**re: Geotechnical Review – Grading and Site Servicing Plan Review
Proposed Residential Building
1146 Snow Street, Ottawa**

date: January 20, 2026

file: PG7295-MEMO.03

SITE GRADING PLAN

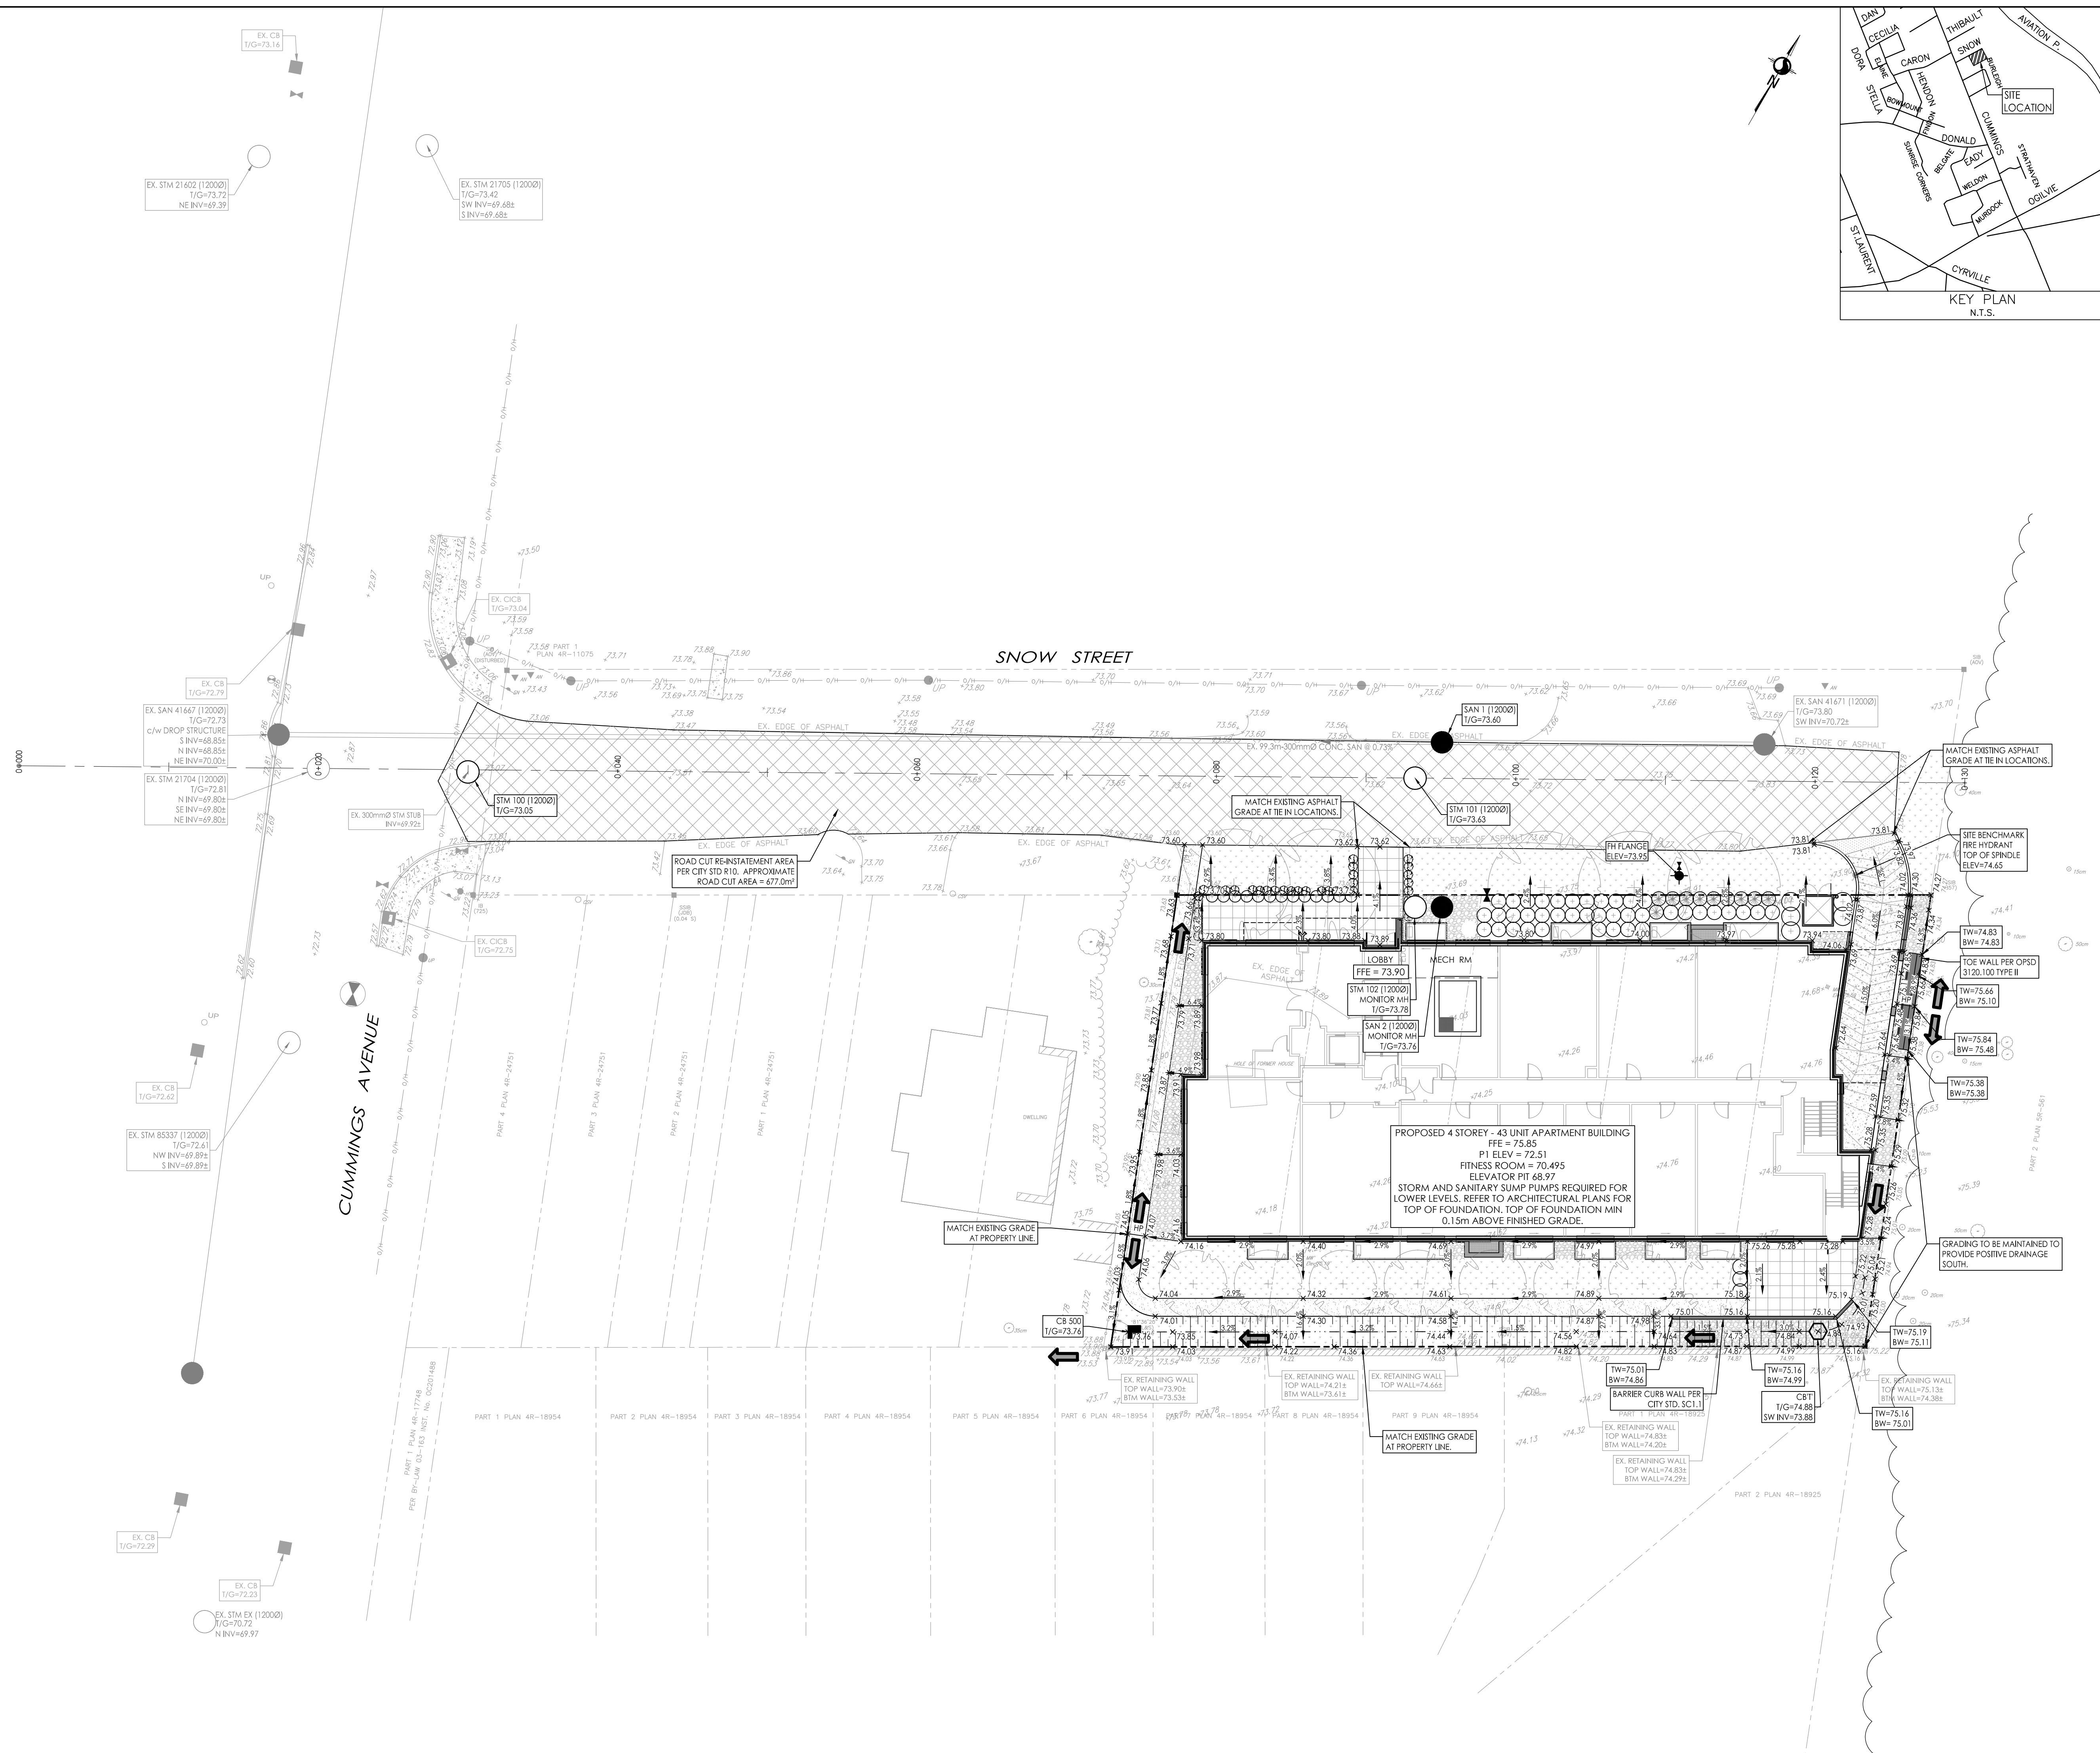
Based on the findings of the geotechnical investigation of the above referenced report, no permissible grade raise restrictions are applicable to this site due to the absence of a sensitive below the marine clay deposit. Therefore, the proposed grading plan is considered acceptable from a geotechnical perspective. No additional measures such as lightweight fill or settlement monitoring programs will be required to accommodate the proposed finished grades as noted on the aforementioned grading plan.

The above-referenced grading plan is in general conformance with our geotechnical recommendations.

DRAWING TITLE: FOUNDATION & BASEMENT PLAN
 DATE: FEB., 2025
 SCALE: 1:75
 SHEET NO.: A1
 DRAWN BY: JB
 CHECKED: MDB

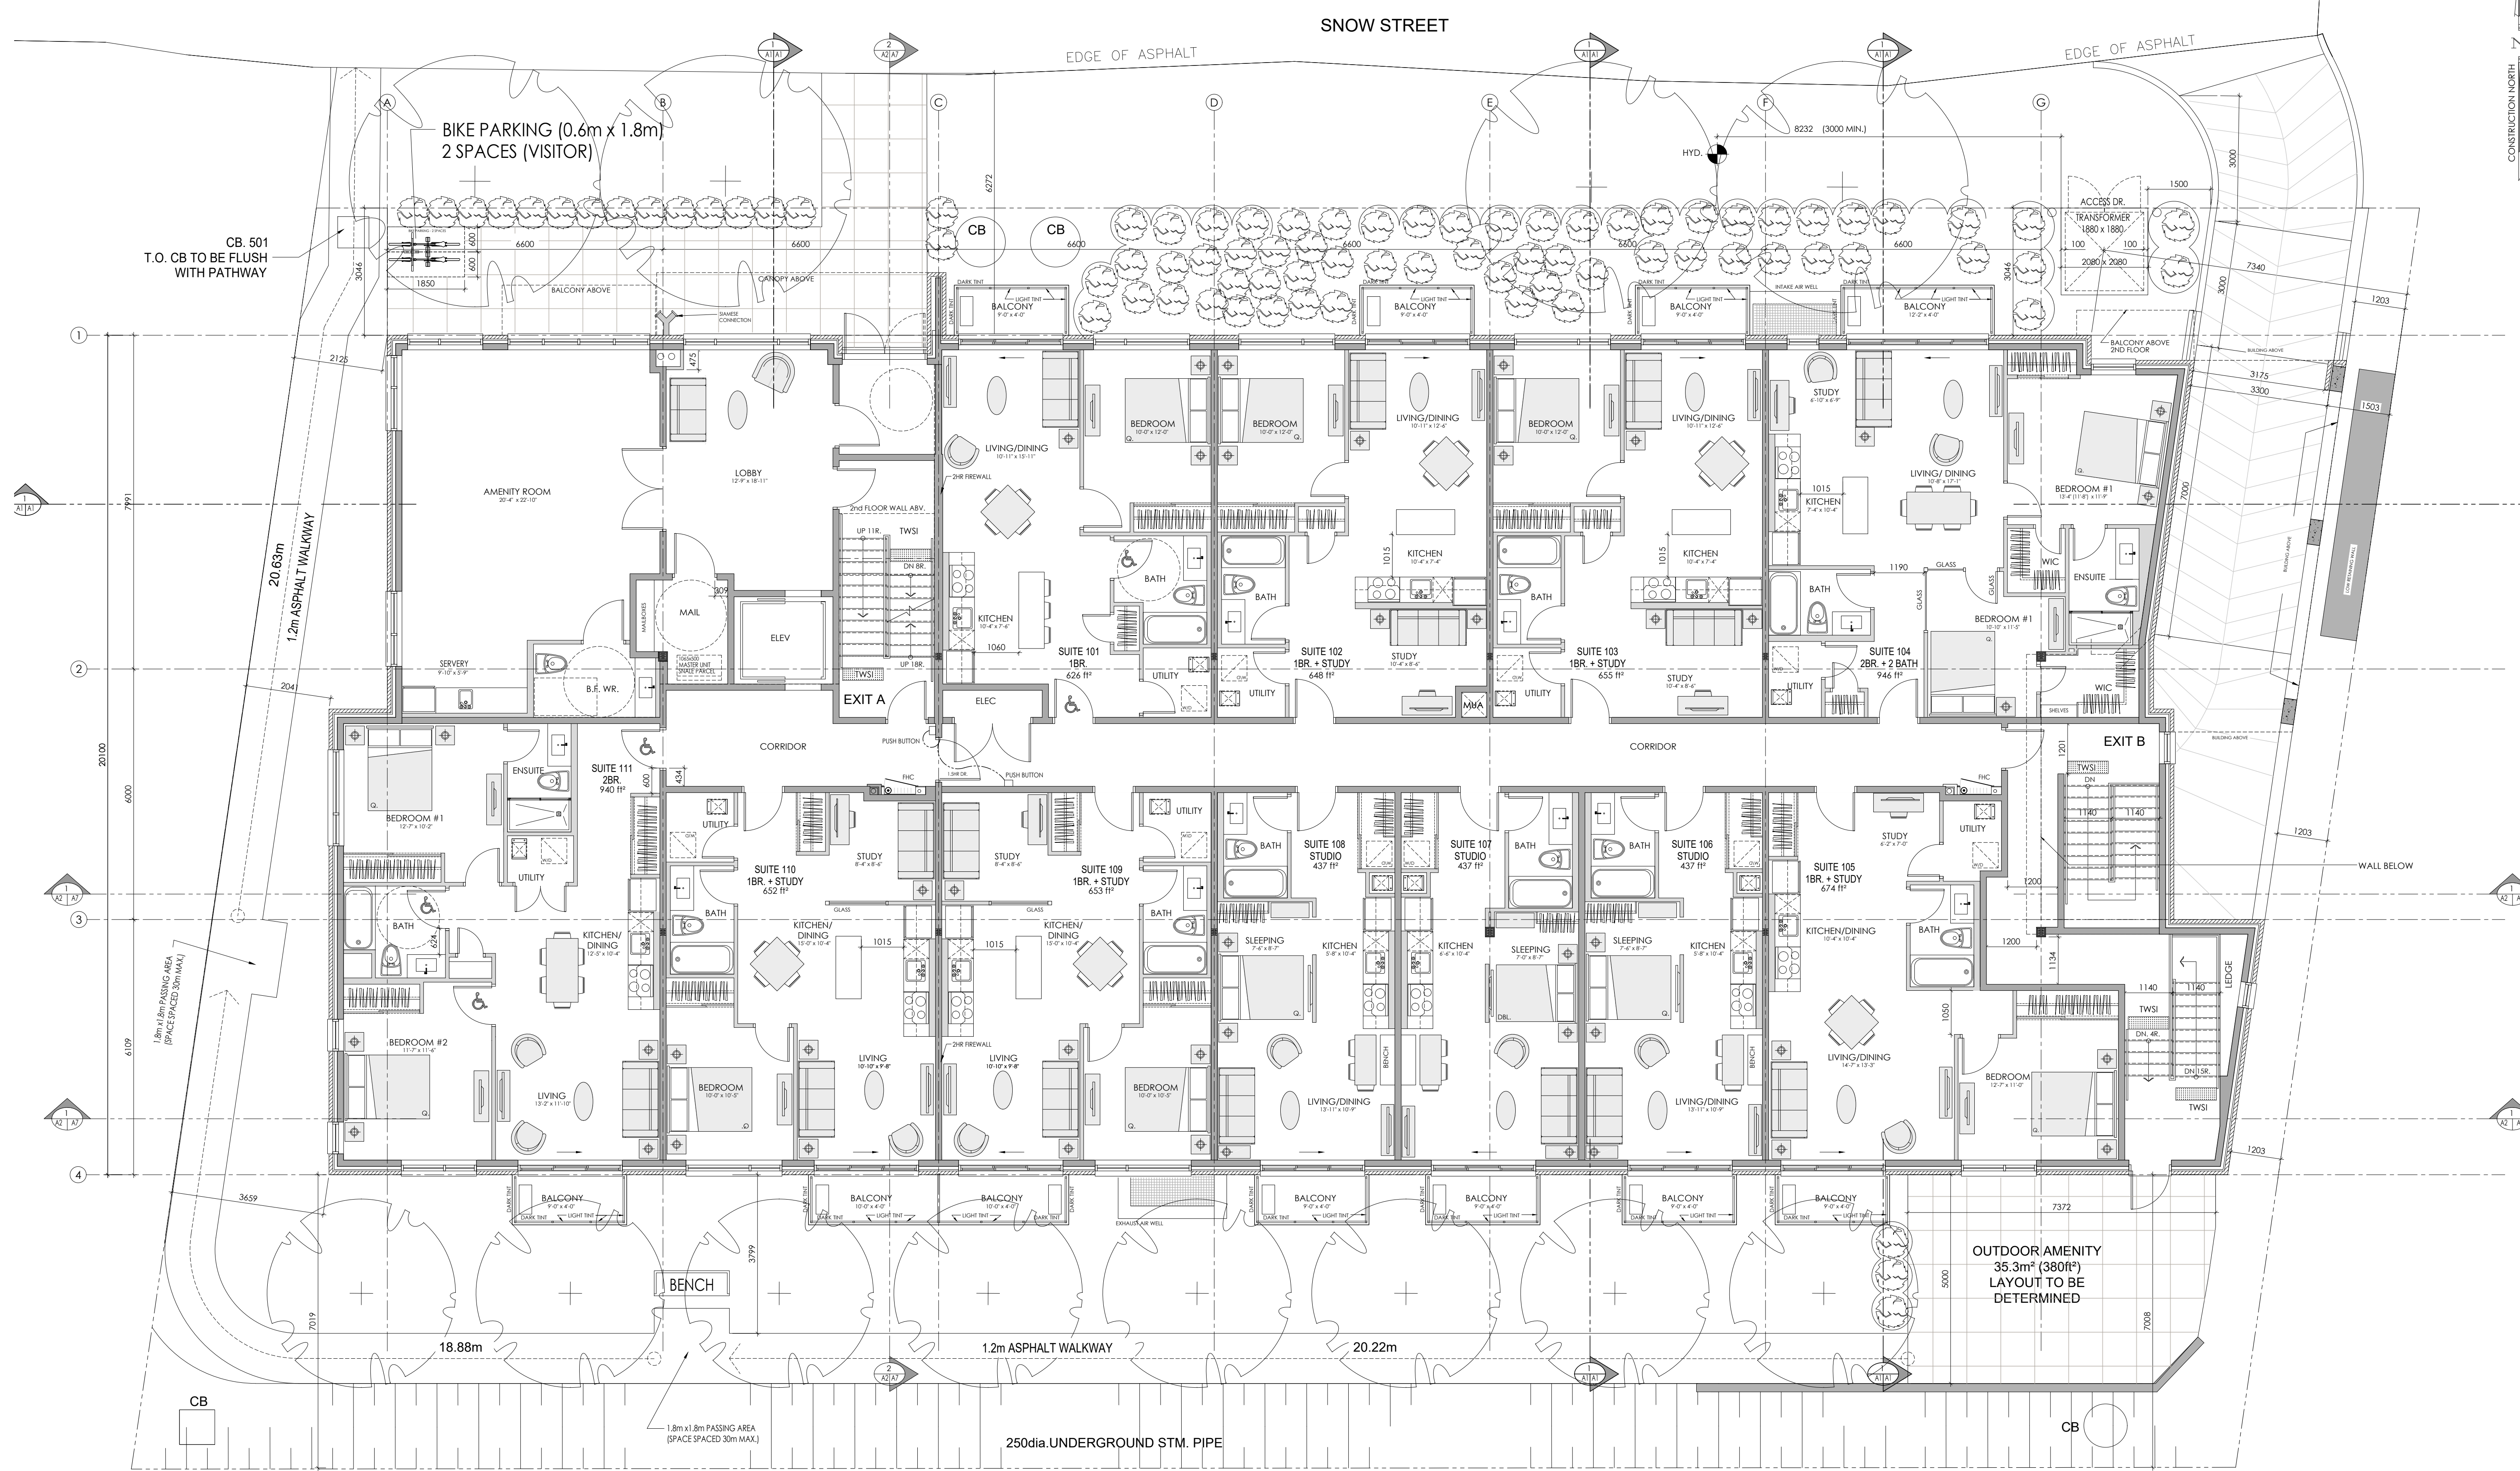
Based on our review of the above referenced architectural drawings – Project No. 19361-Drawings A1 to A7, Revision 3, dated November 12, 2025, the USF elevations of the building will vary between 69.845 m to 70.975 m and the USF elevation for the elevator shaft will be located at 69.62 m.

The underground basement level as well as the fitness room level are expected to be heated. Thus, perimeter footings of the underground basement structures are required to be insulated against the deleterious effects of frost action. A minimum of 1.5 m of soil cover alone, or a minimum of 0.6 m of soil cover, in conjunction with adequate foundation insulation, should be provided. Based on our review of the above-referenced architectural drawings, all the building footings were noted to have a minimum 1.5 m of soil cover.
